**DRAINAGE REPORT**  
for  
**Desert Ridge Trails North**

March 10, 2003

**Re: Desert Ridge Trails North Subdivision ZAP C-19 (COA Rpt B19-D21)**

TITLE: DESERT RIDGE TRAILS NORTH
GRADING AND DRAINAGE PLAN

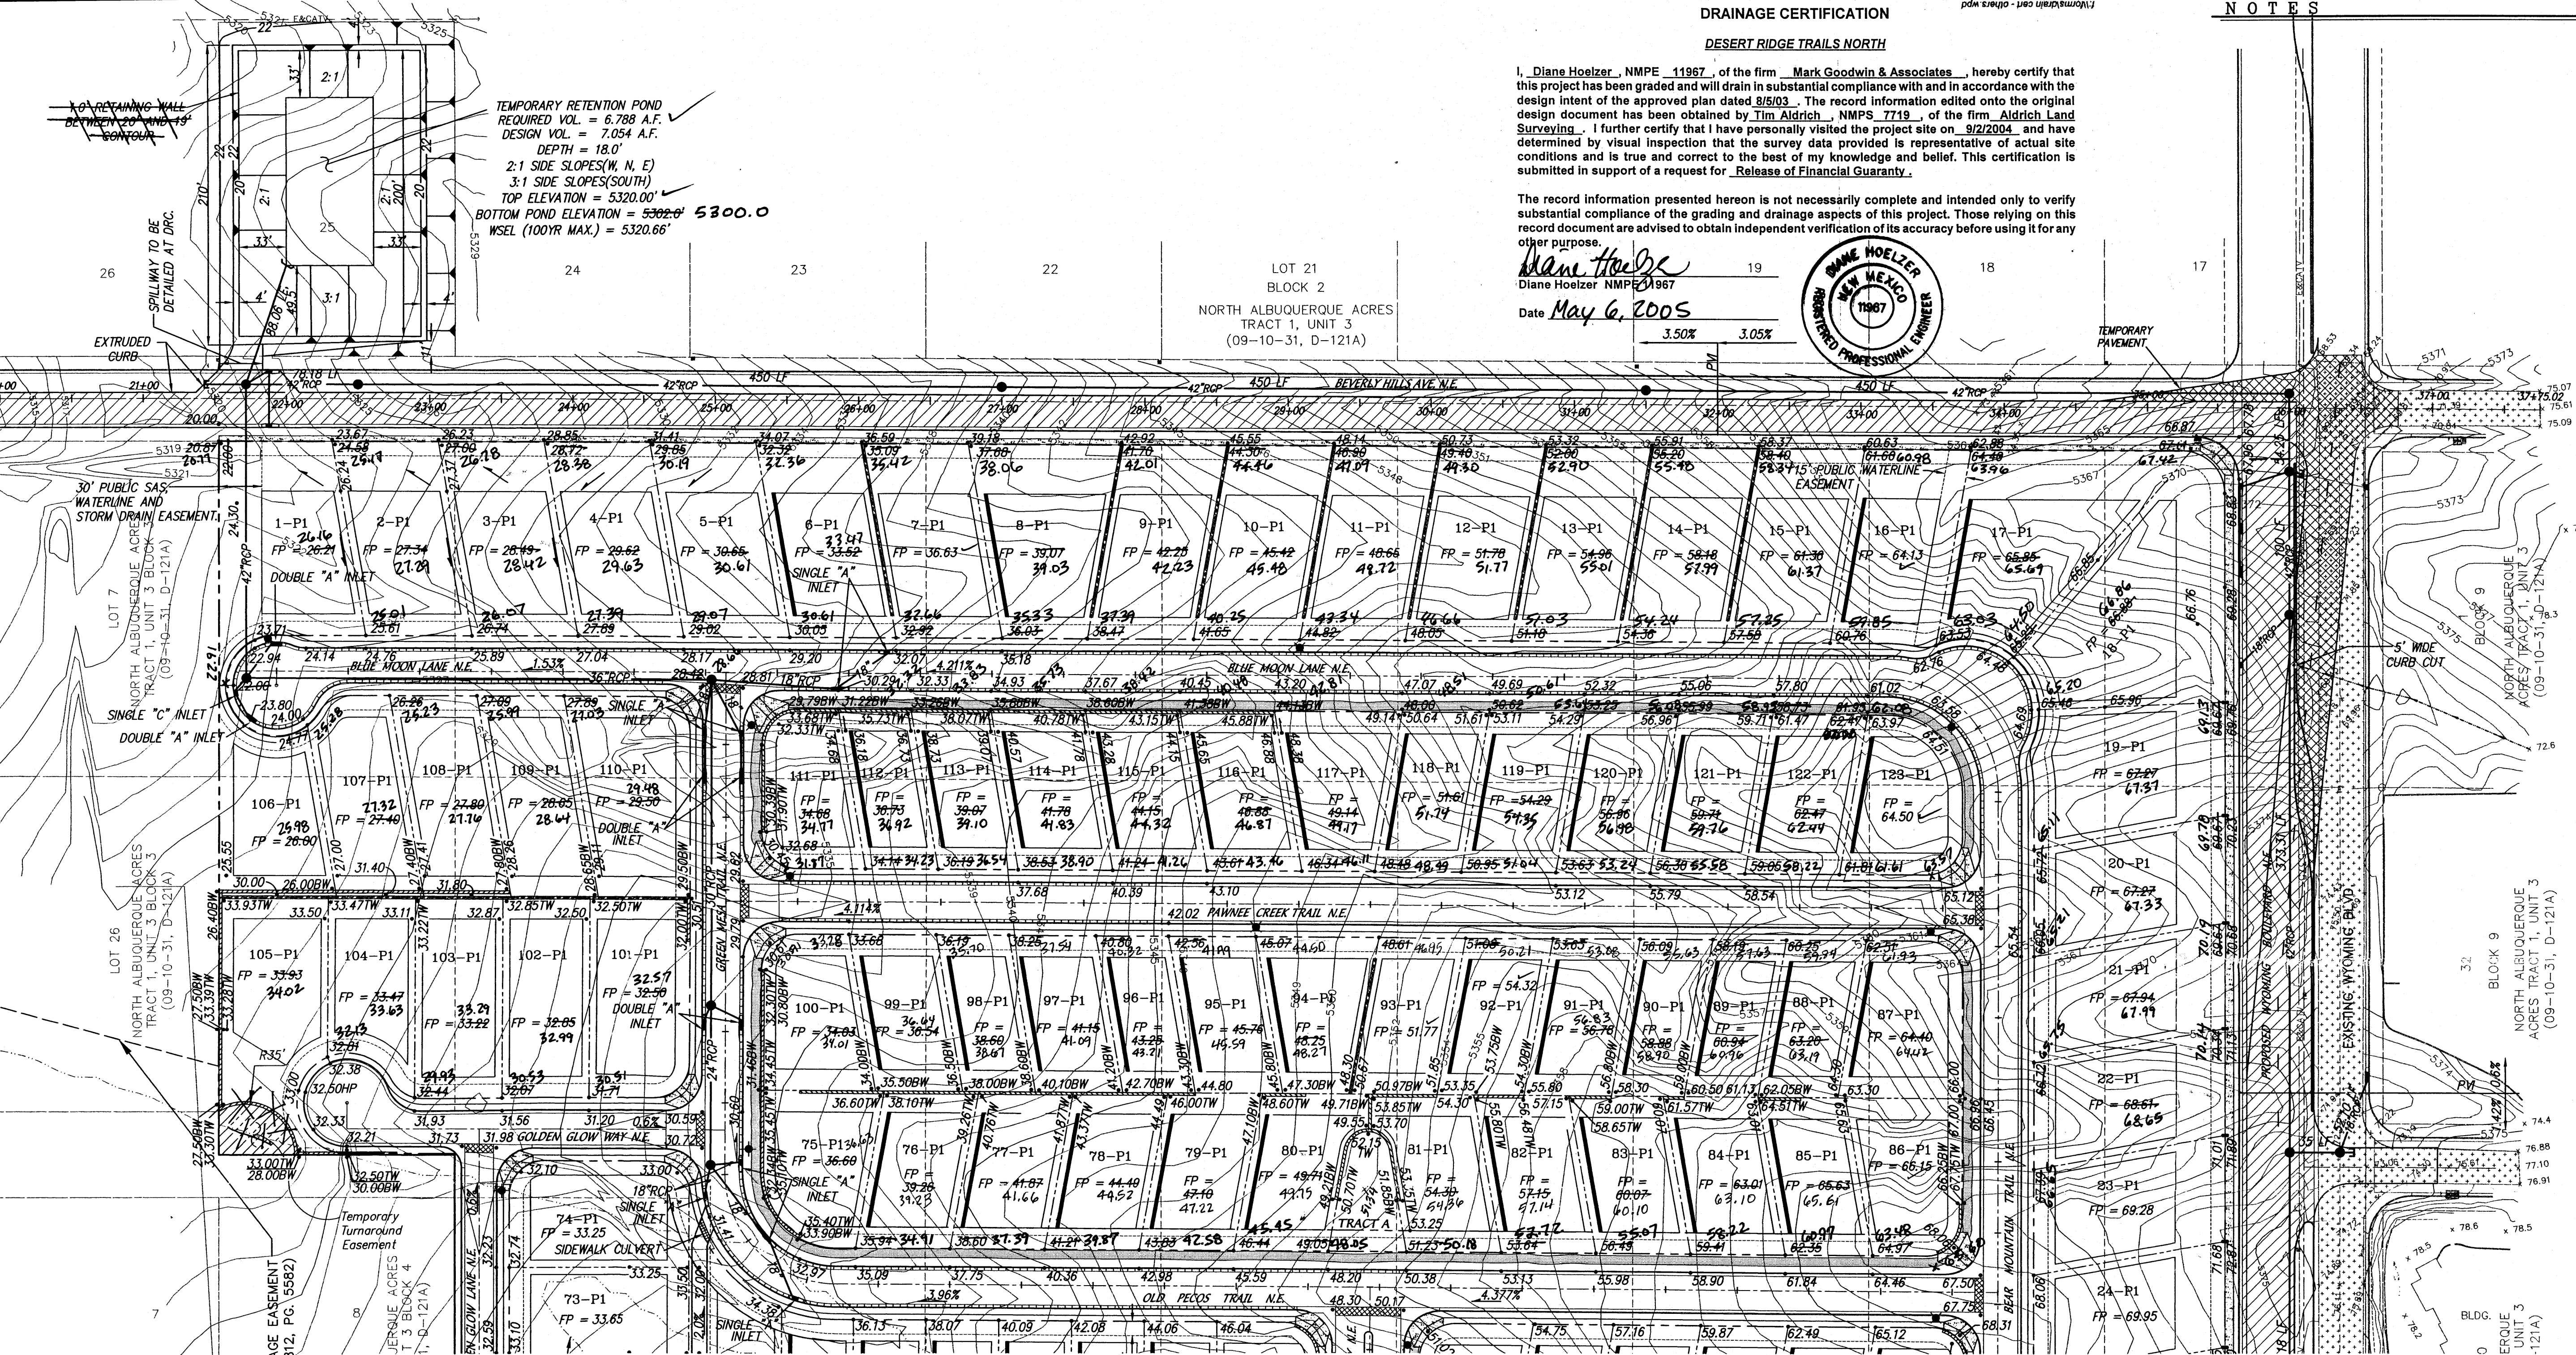
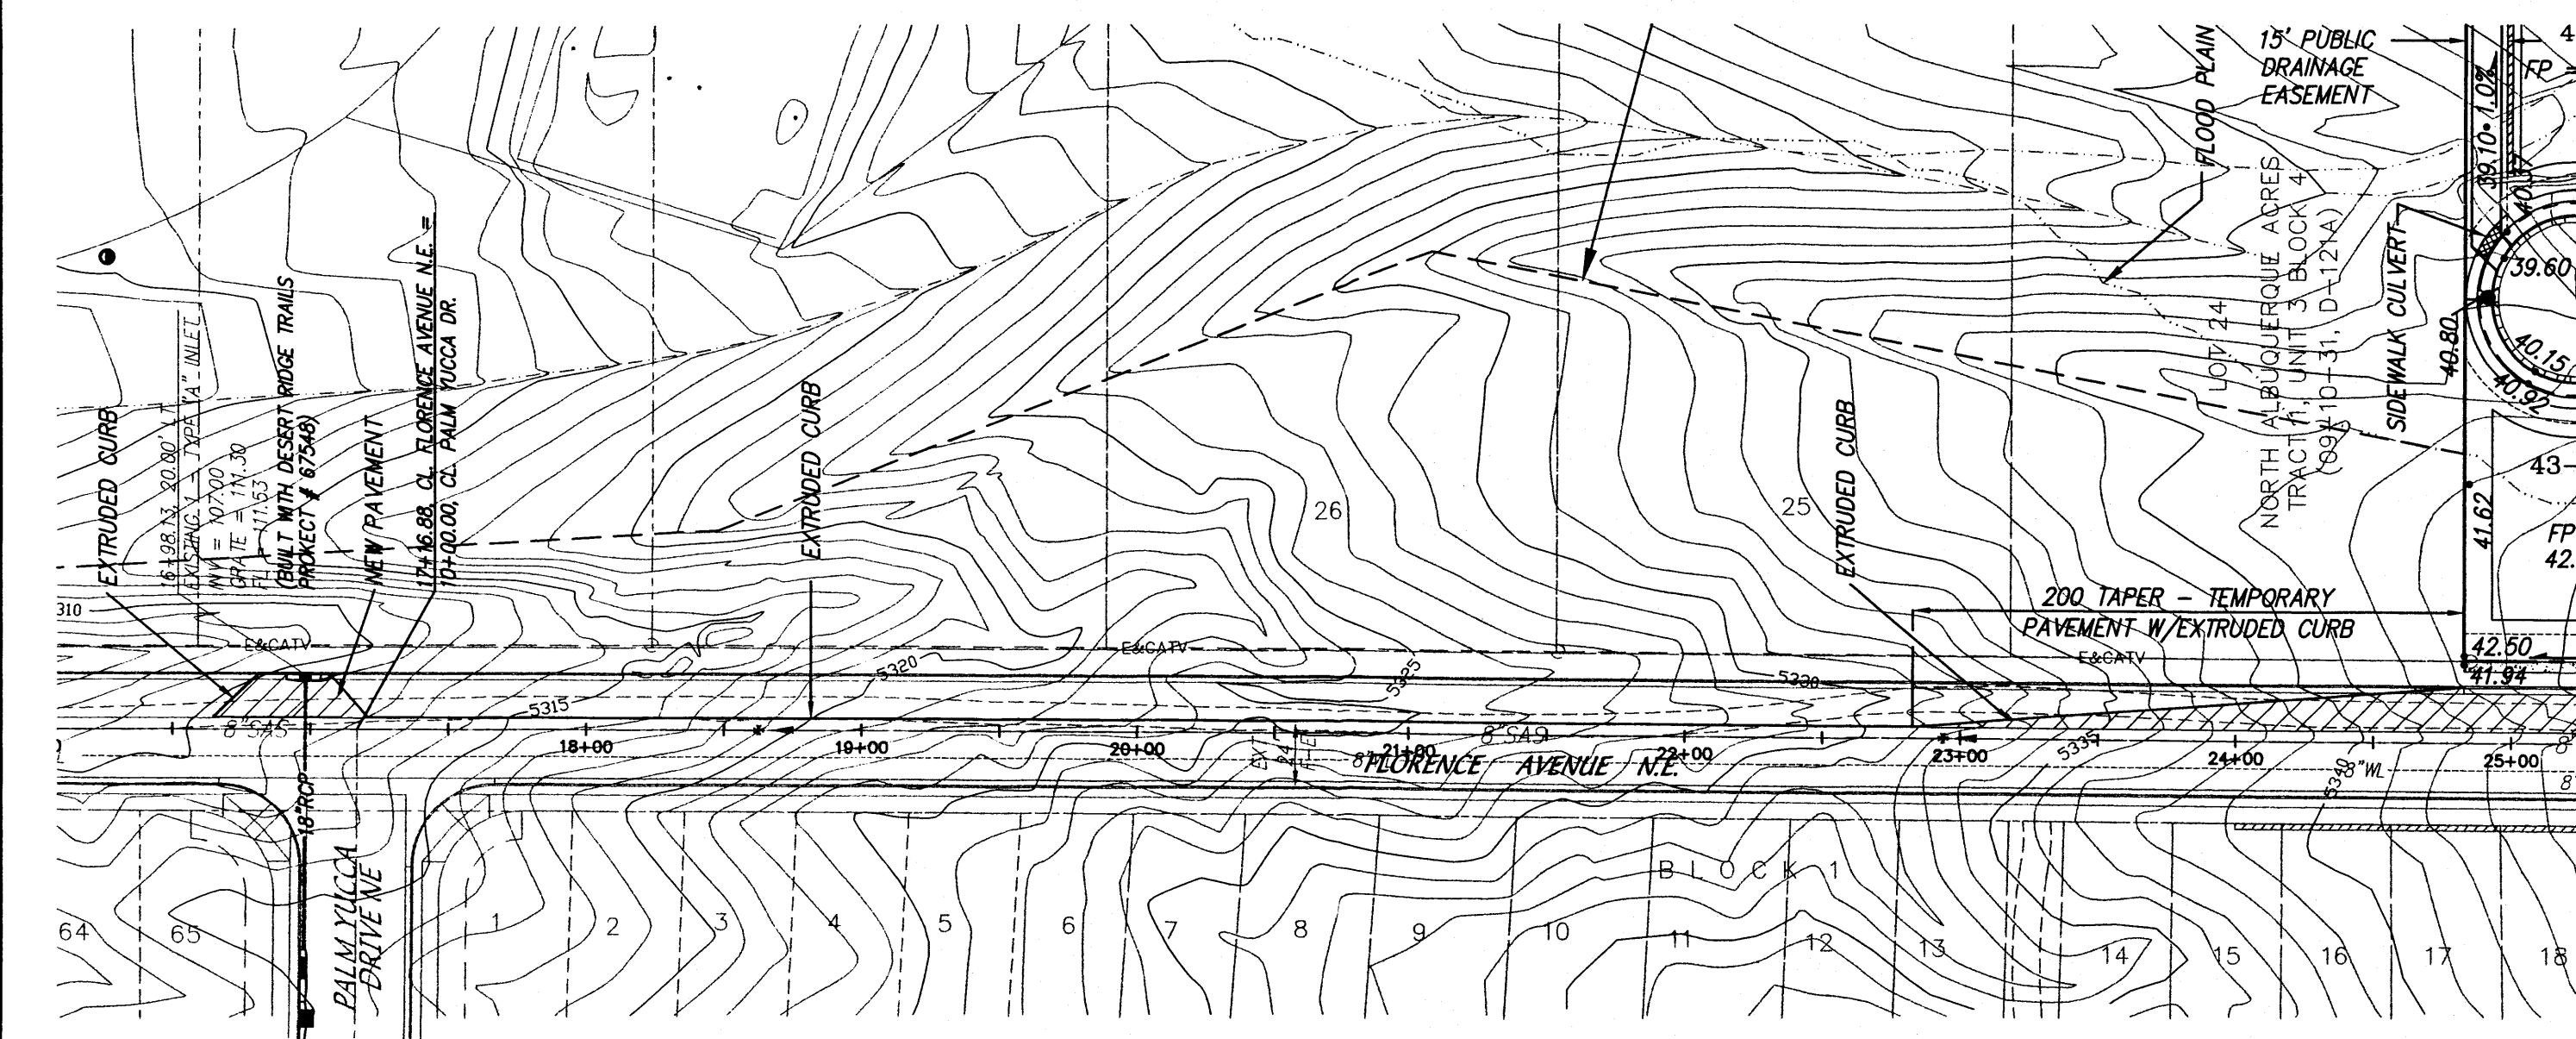
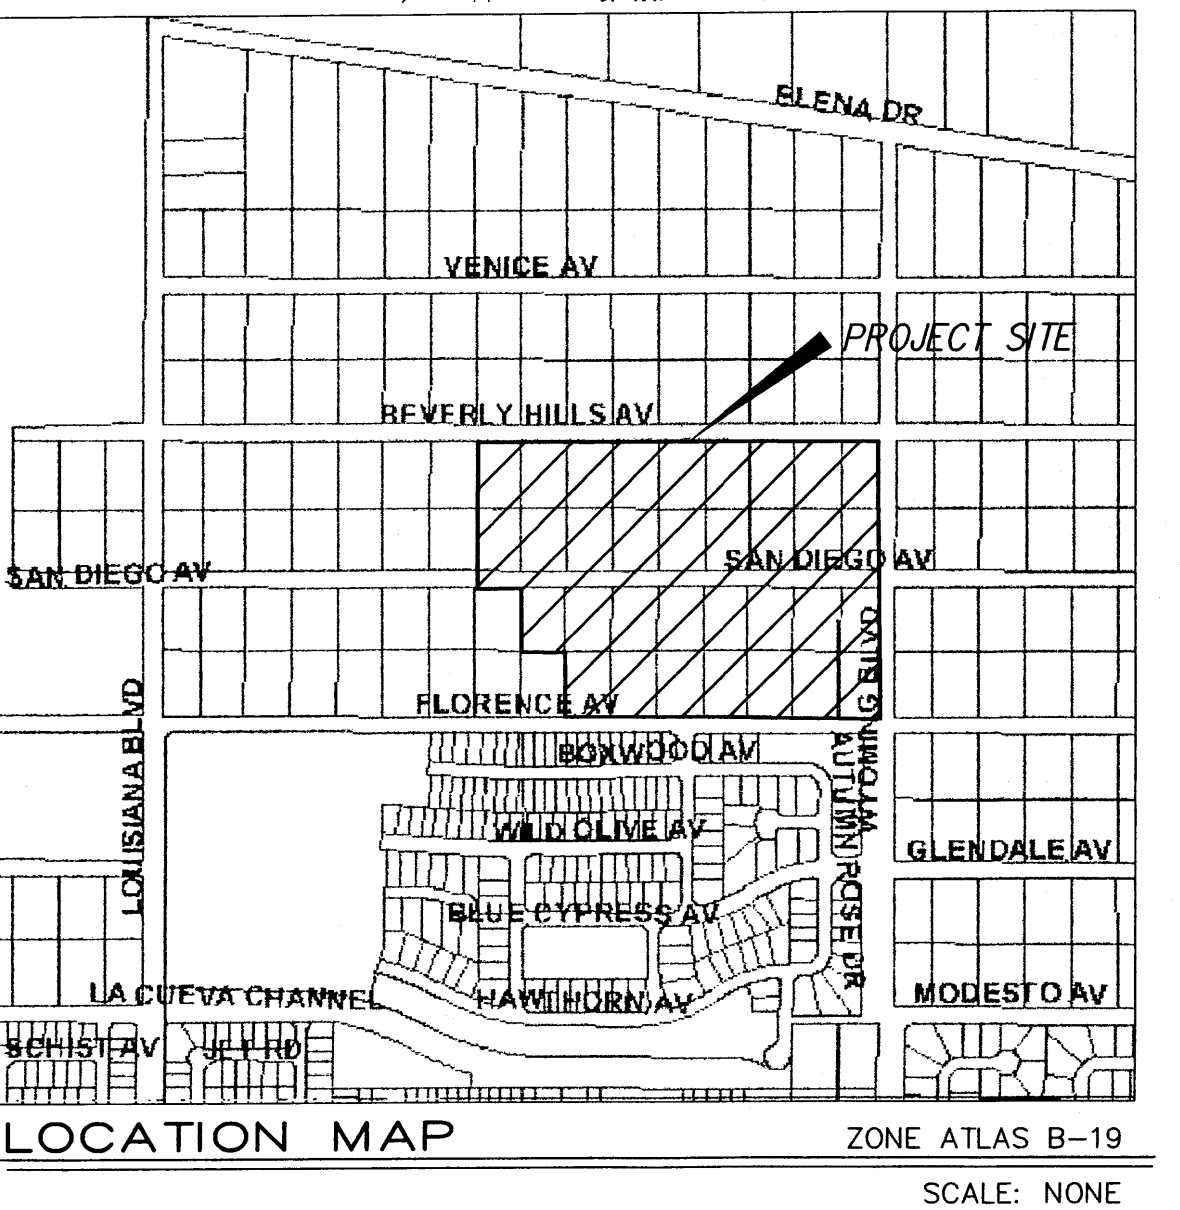
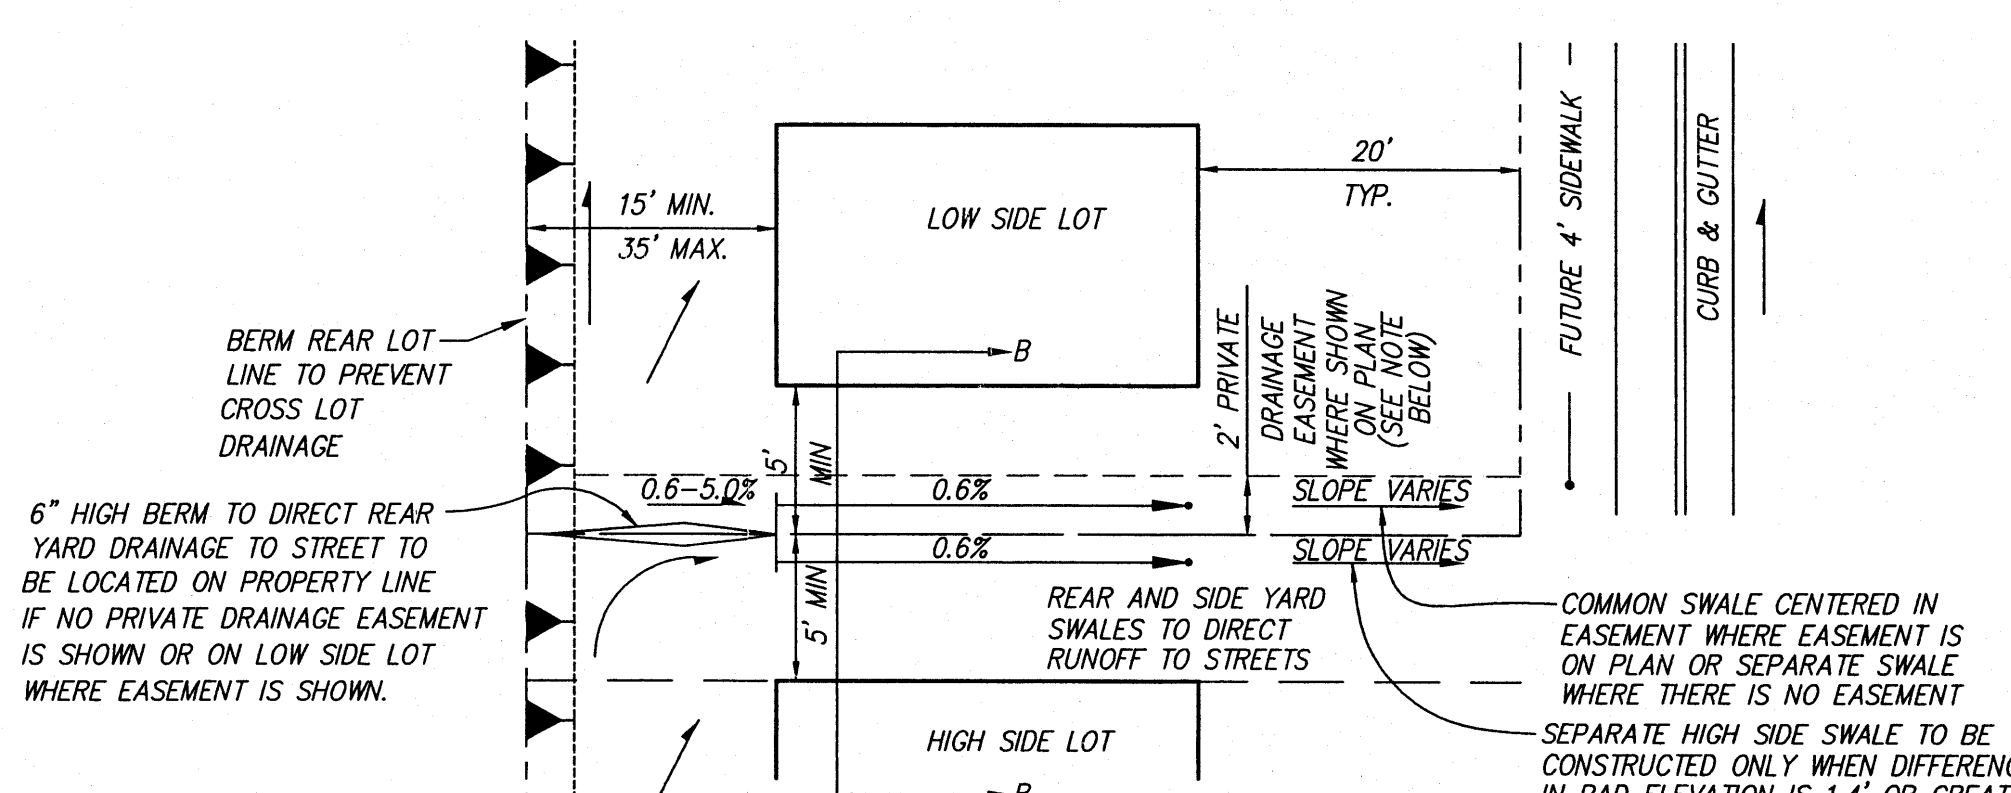
3. *The revised grading and drainage plan shows that the additional runoff from the north side of Florence Avenue as a result of construction from this project will be intercepted by an inlet on the north side of Florence at the intersection of Palm Yucca Drive. This inlet is already constructed and connected to the existing storm sewer system in Desert Ridge Trails. The Storm sewer analysis for this system was included in Appendix C as 'Stormplus Florence Avenue Diversion'.*

4. *The revised G&D plan gives all the required dimensions necessary to construct the pond for the required runoff capacity. Historically, as shown on the 'Existing Offsite Drainage Conditions Exhibit', runoff from our project site and offsite subbasins 204.1AE, 204.1BE and 204.4AE have been diverted along the south side of and in Beverly Hills Avenue and then across Louisiana and back into the natural arroyo channel. Per our meeting on March 3, the proposal is to construct the south half of Beverly Hills from the west end of our project site to Louisiana Blvd. and divert any spillway flows from the pond in Beverly Hills westward across Louisiana and back into the arroyo. This will be accomplished in a 24' wide pavement section with curb and gutter along the south side and extruded curb along the north side.*

*The pond will be dedicated as a 'public drainage easement' and the standard 'Agreement and Covenant' will be executed with either the developer or the Home Owners Association being responsible for maintenance of the pond.*
5. *Under existing drainage conditions, Lot 7,8 and 9 drain in a west to northwest direction. This historical flow pattern will not change with this development. At this time our client has control over Lot 9. The access issue has been resolved through the creation of a temporary turnaround easement as shown on the revised grading and drainage plan and as will be shown on the final plat.*
